STRUCTURAL TEST AND INSPECTIONS REPORT

FIELD REPORT NO: 11

Project: **53 Danforth Street**
Portland, ME 04101

Date: **02/03/09**
Temperature/ Weather: **Sunny, 25F**

# SHEAR WALL SCHEDULE

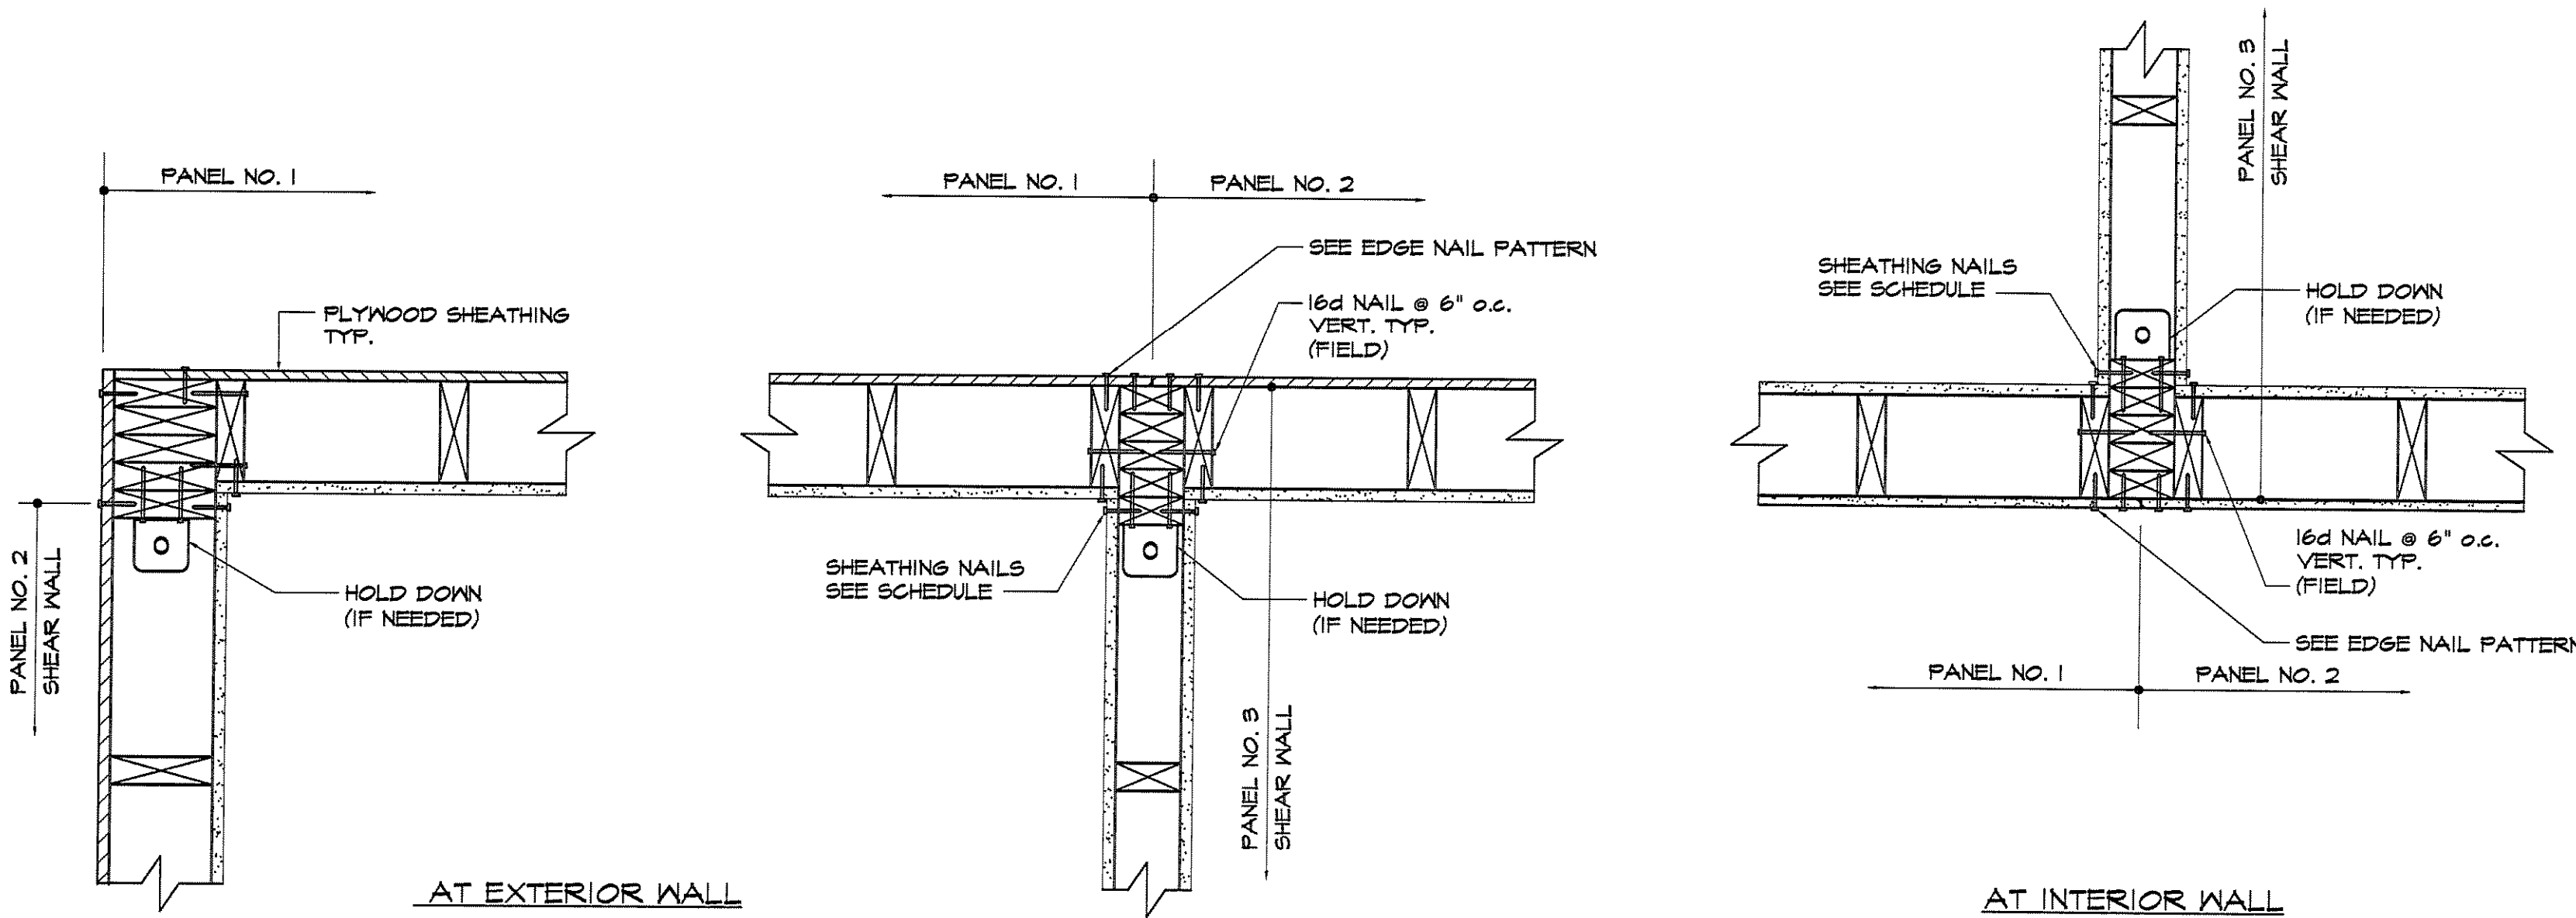
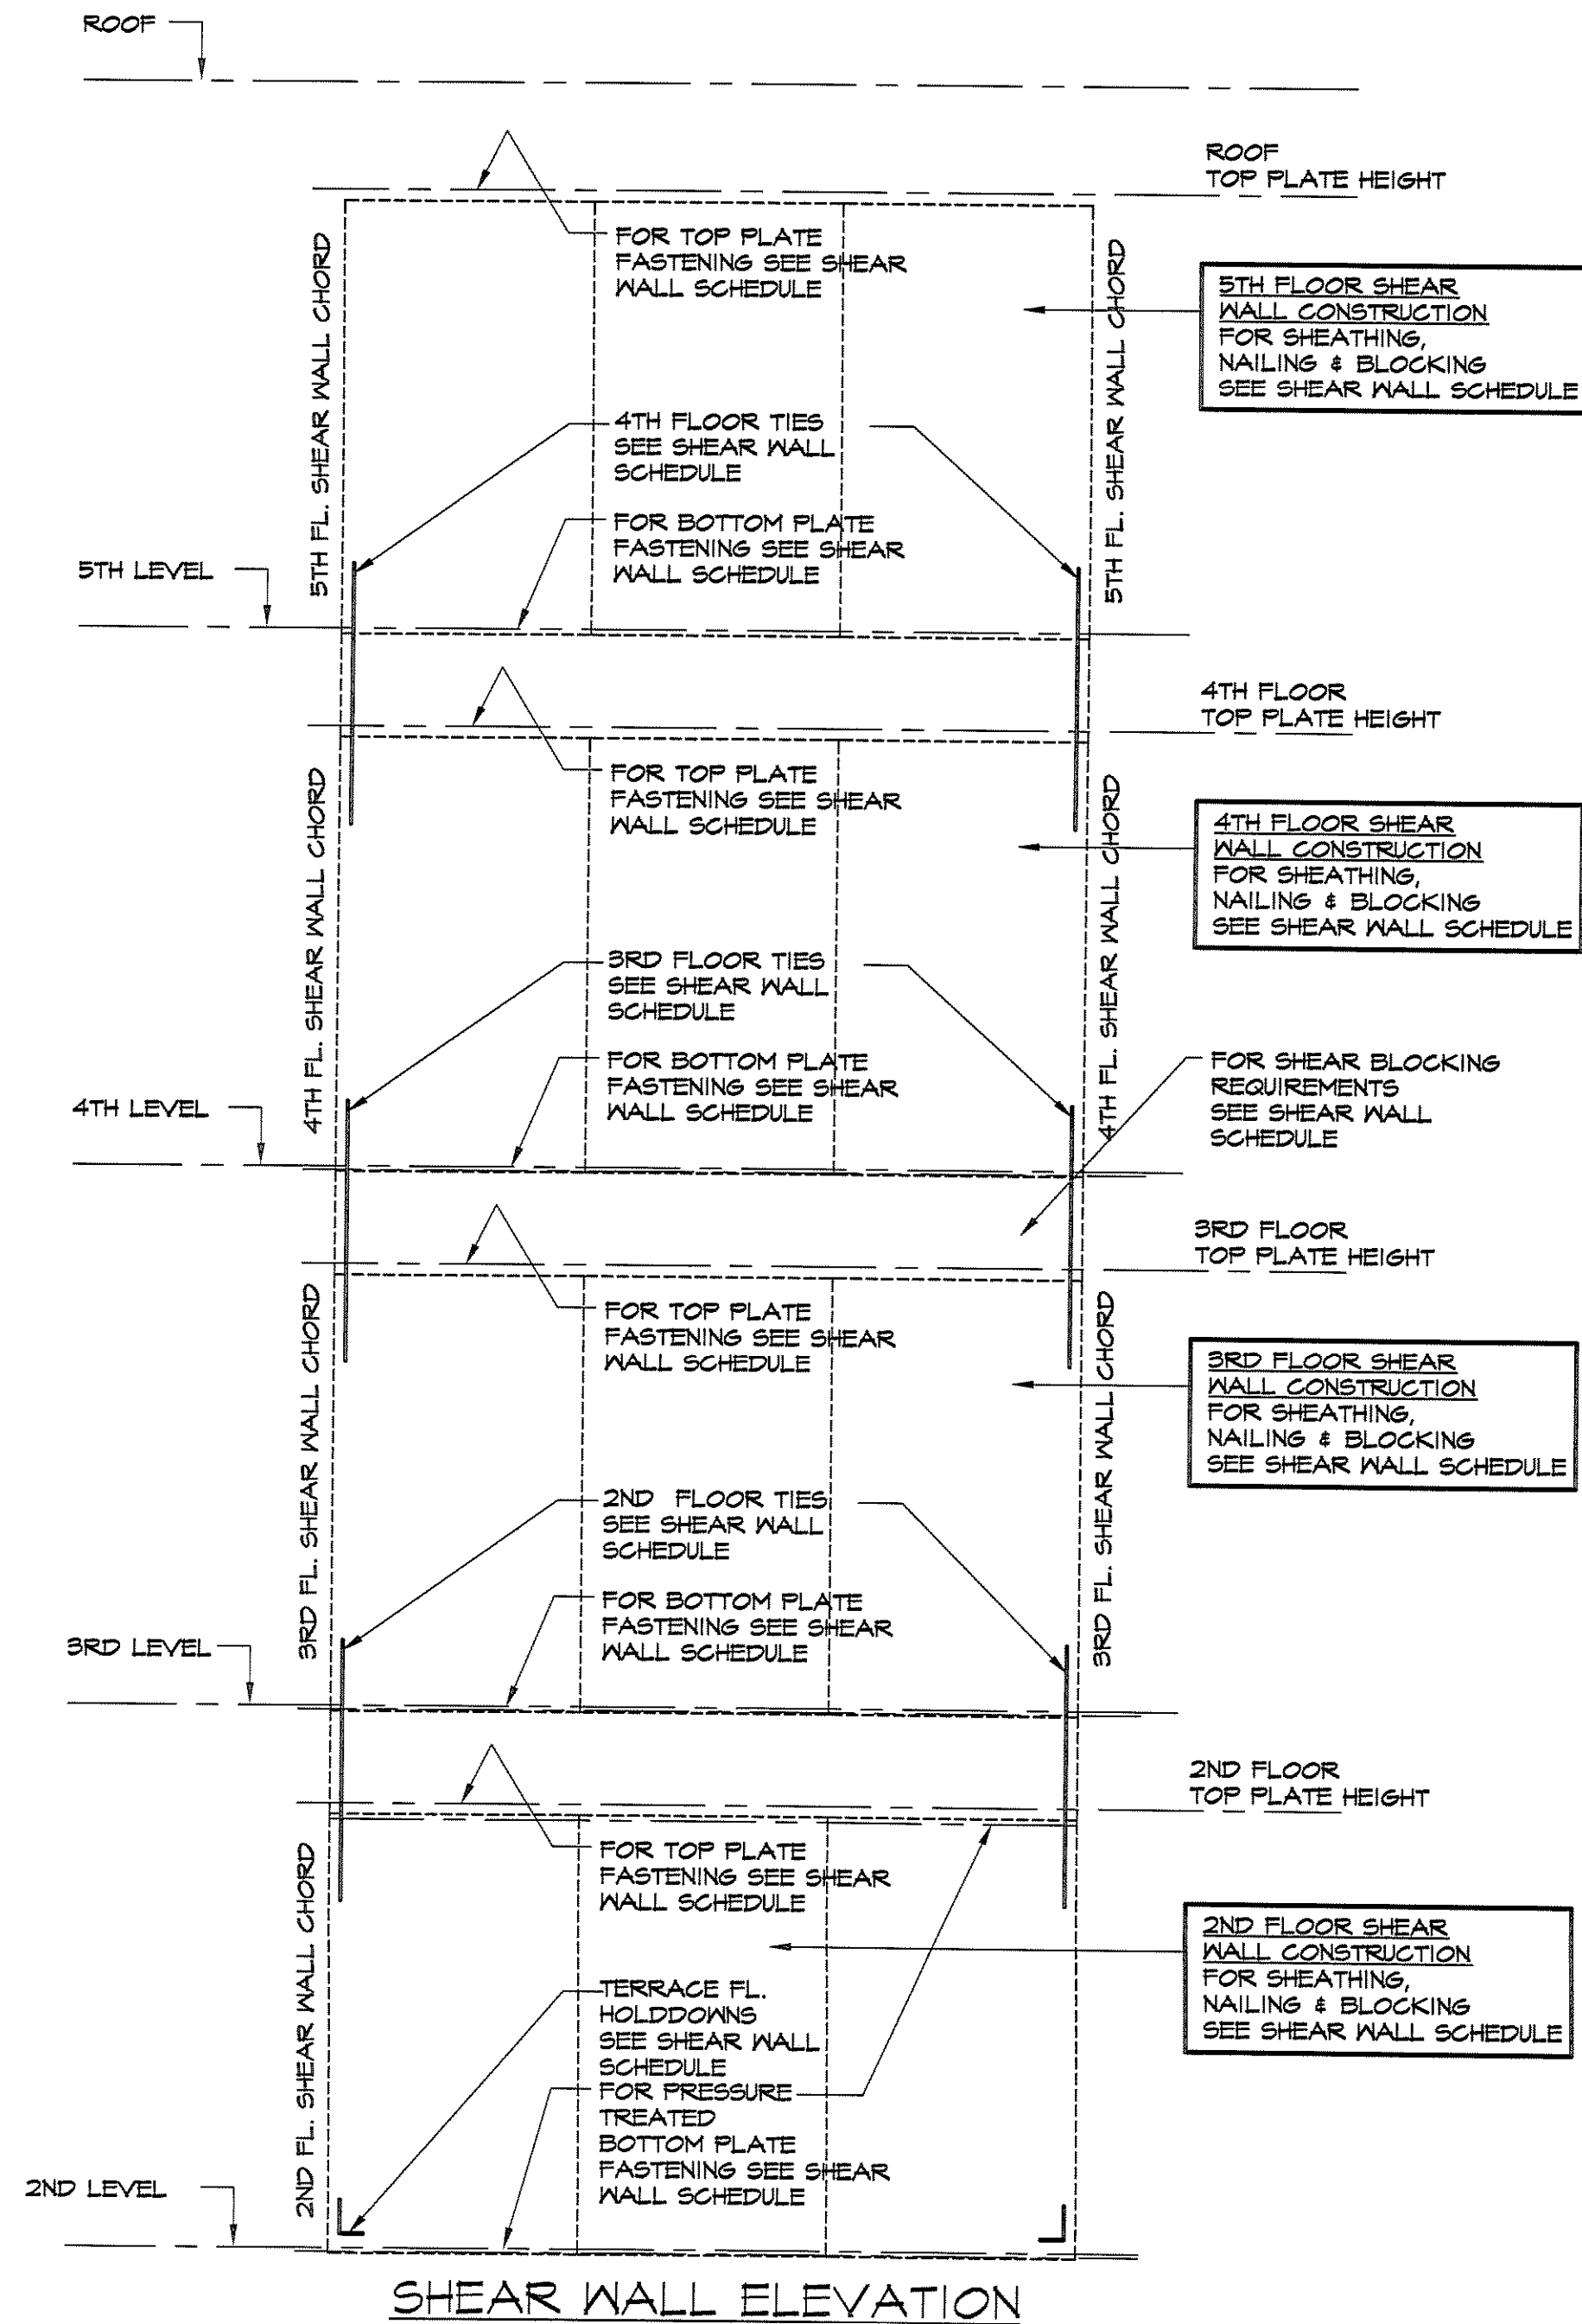
- 11.1 All hold down brackets require 2-2x6 double studs, add double 2 x stud as needed.
- 11.2 Add shim under holddown.
- 11.3 May require holddown (review)
- 11.4 Add squash blocking at all holddown strapping locations (inside floor cavity) remove kink by nailing strap to blocking (also known as compression blocks).
- 11.5 Make sure all bolts are tightened on holddown (holddown bracket remains to be installed at 2 locations).
- 11.7 Examined the condition of the drop beam below the first level slab.
- 11.8 Three windows at the second level rear/left elevation, require four jack studs. However only one jack stud exists (review).
